Application for a Non-Material Amendment Following a Grant of Planning Permission

Land at Yiewsley Library and Former Yiewsley Pool,

76795/APP/2023/2503

Non-Material Amendment(s) Sought

NMA - Proposed Site Plan
YIEWSLEY LIBRARY SITE

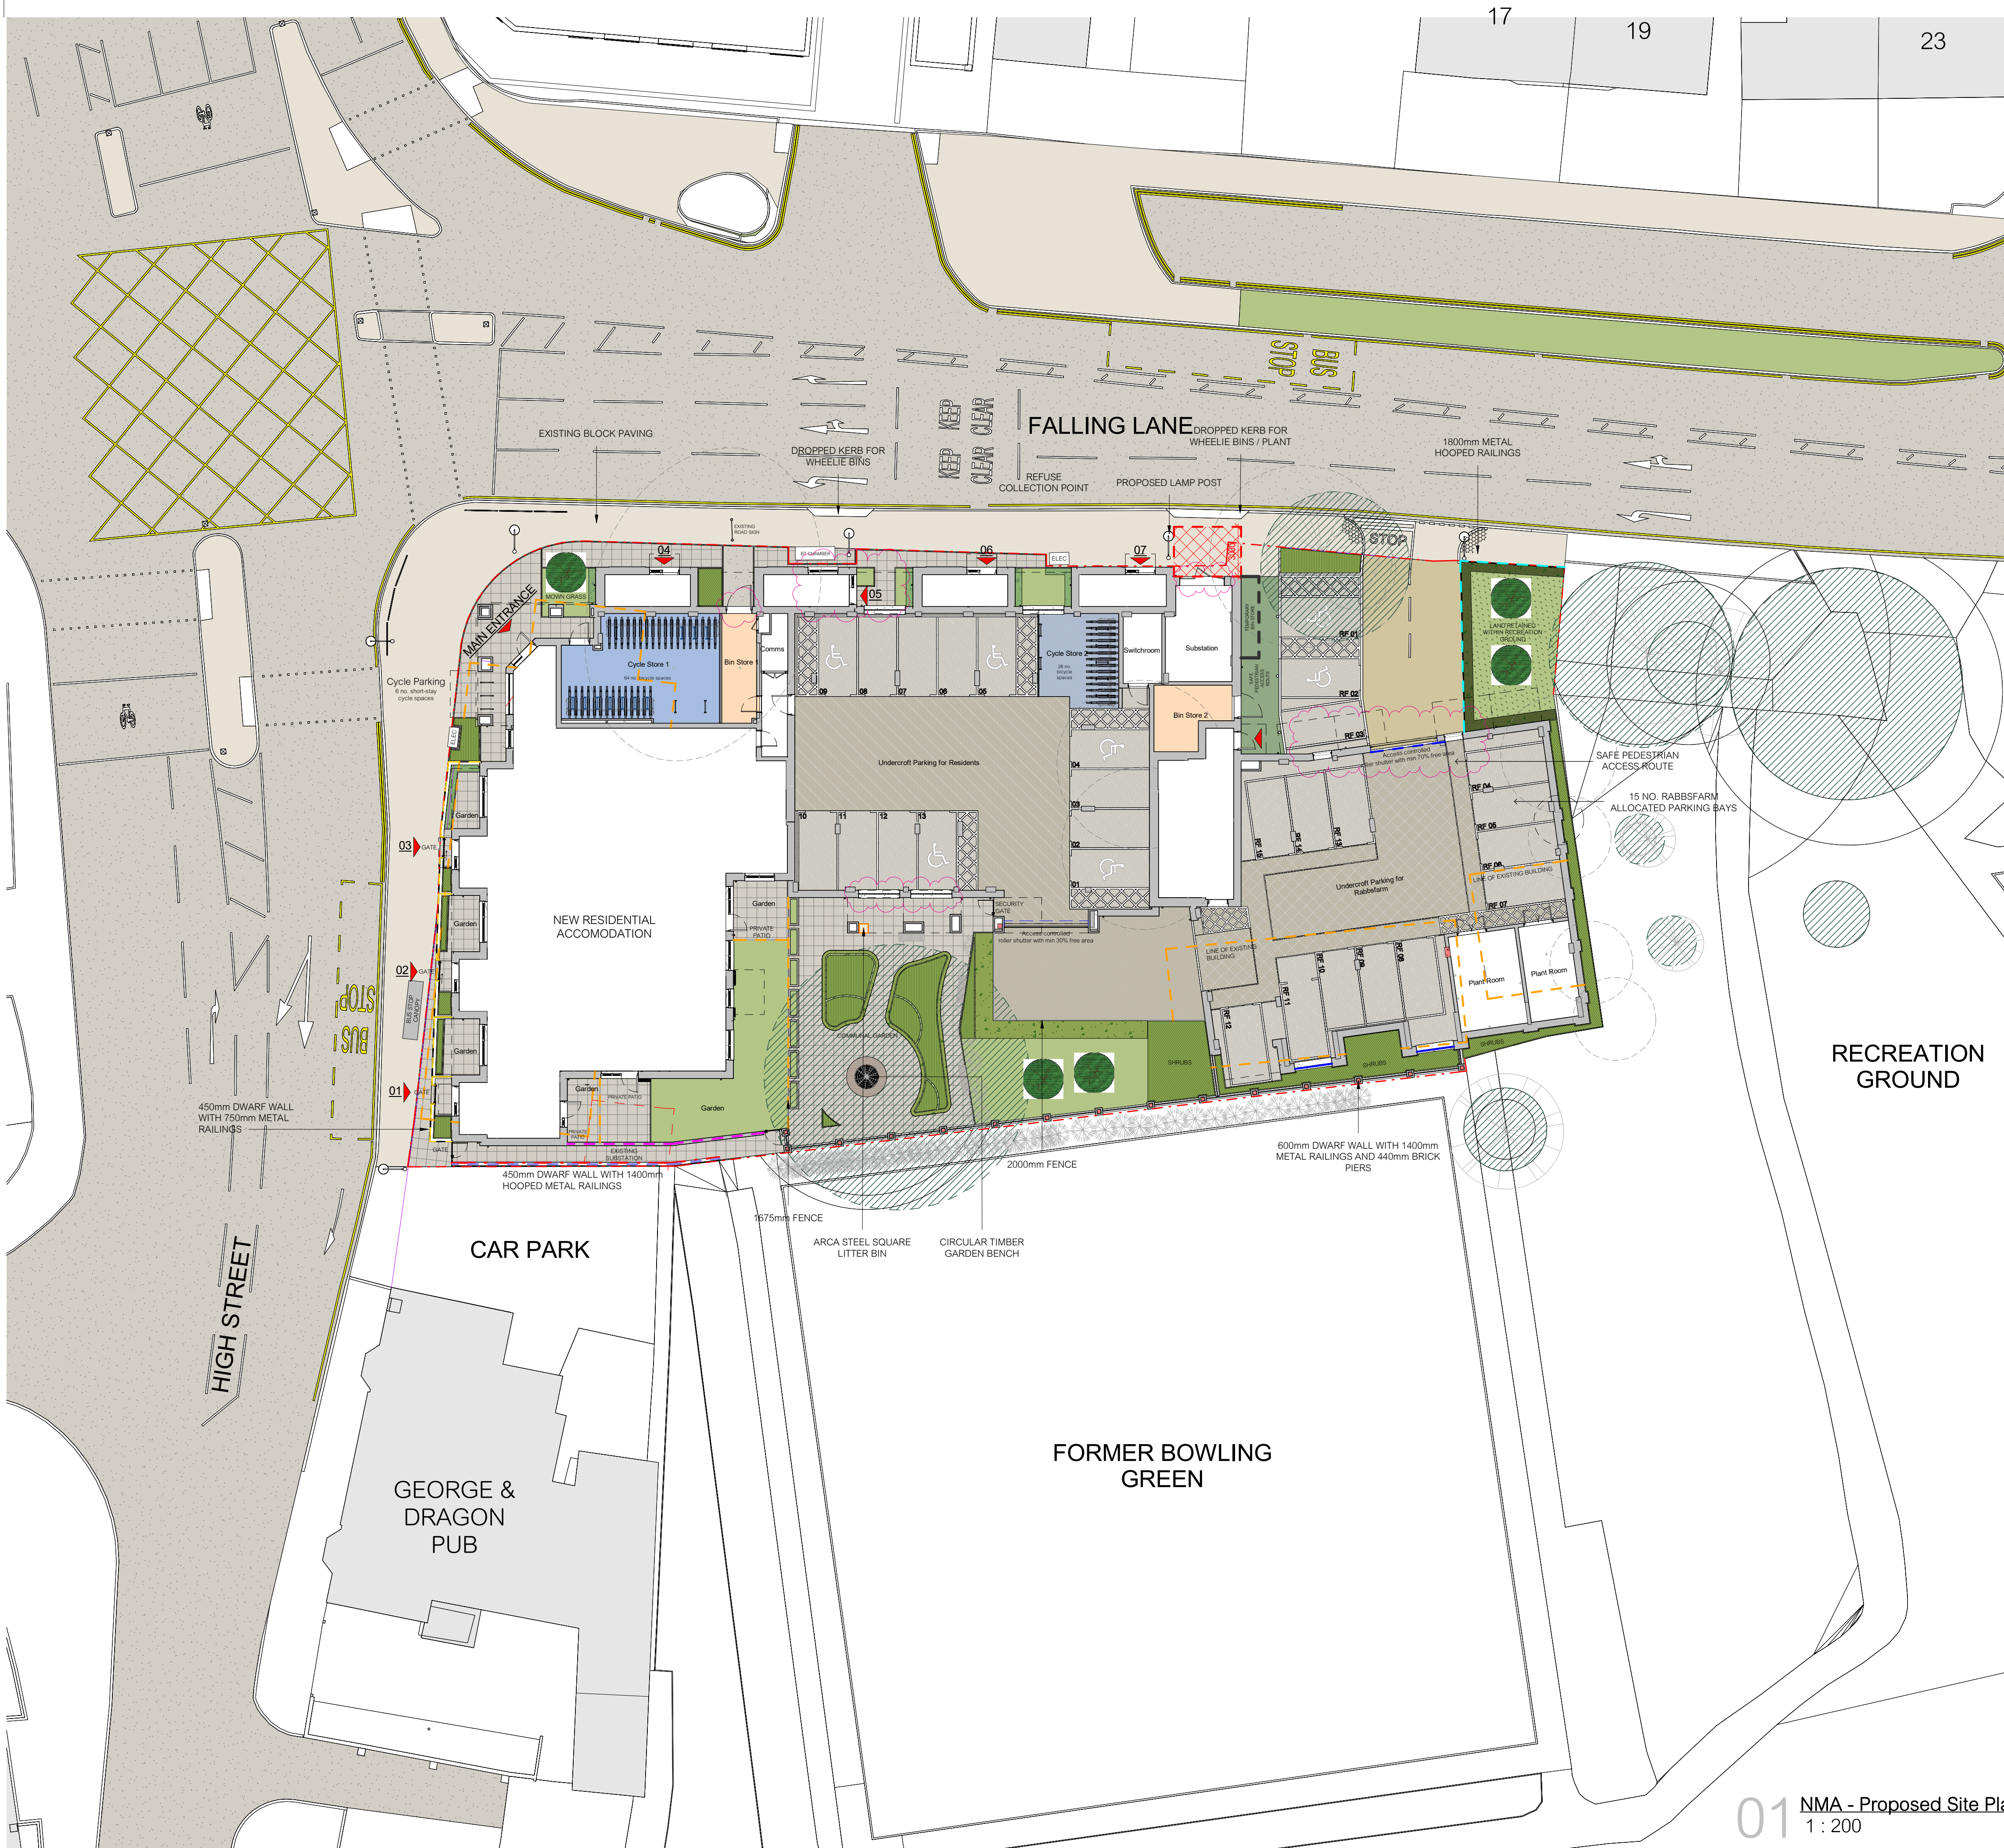
Replacement of the hit-and-miss brickwork to the rear of the residents' car park with railing (aligning with the elevational treatment along Falling Lane) to meet the free-area requirements necessary for ventilation under the fire strategy.

Louvers and shutter added to Rabbsfarm car park – The Shutter is a Secure by Design requirement and ventilation requirement for fire strategy.

NMA - Proposed Roof Plan

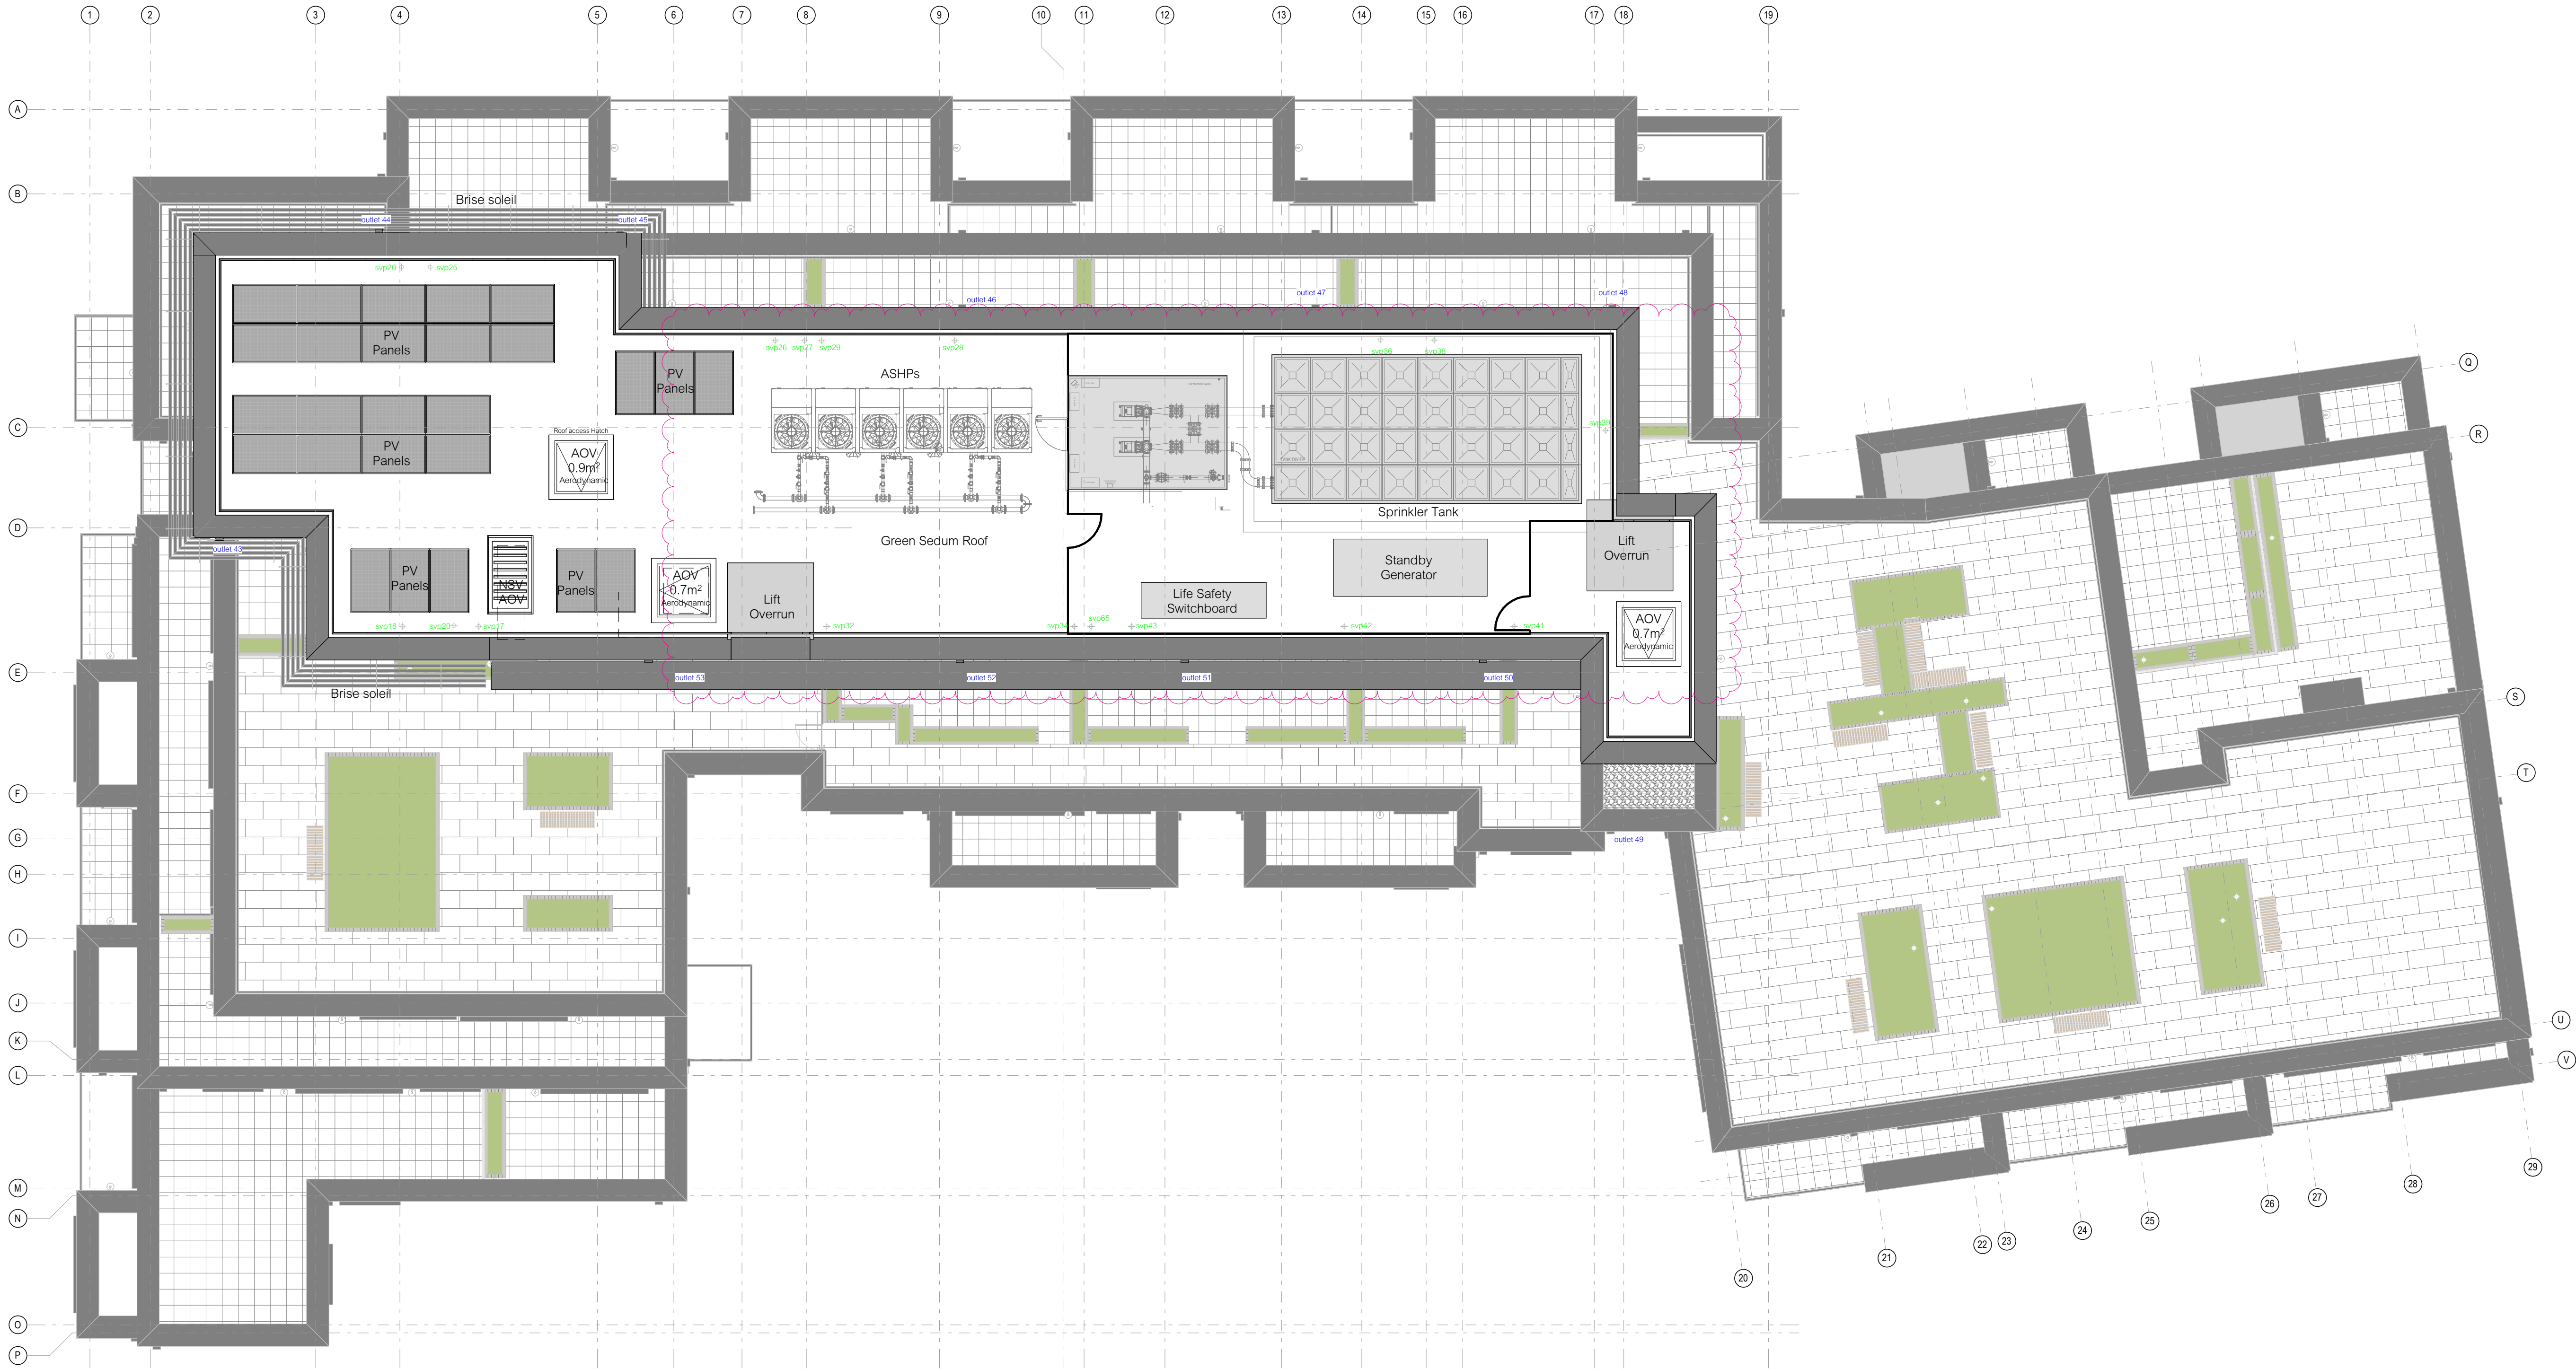
Revision to the location and size of the roof-level plant and associated screening. This is primarily due to the requirement for a larger than previously designed sprinkler tank which is now to be located on the roof rather than underground due to space requirements and maintenance and pump pressure. - The proposed screening is a logical extension of that which is currently approved;

NMA - Falling Lane and High Street Elevations 01 & 02

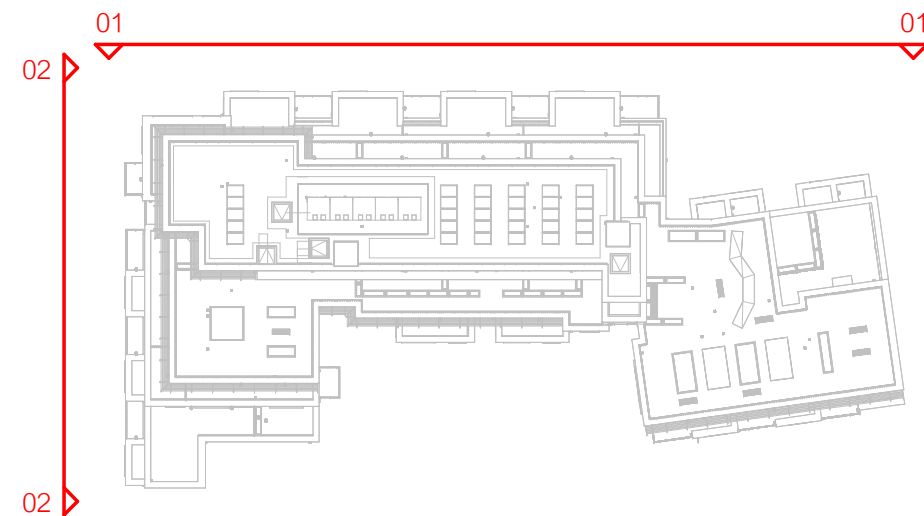
The ground floor secondary entrance door to Unit 05 has been relocated to the return, with a new window introduced in the original door position (to maintain architectural rhythm along Falling Lane) and the associated pathways adjusted accordingly to avoid a clash with the BT chamber.
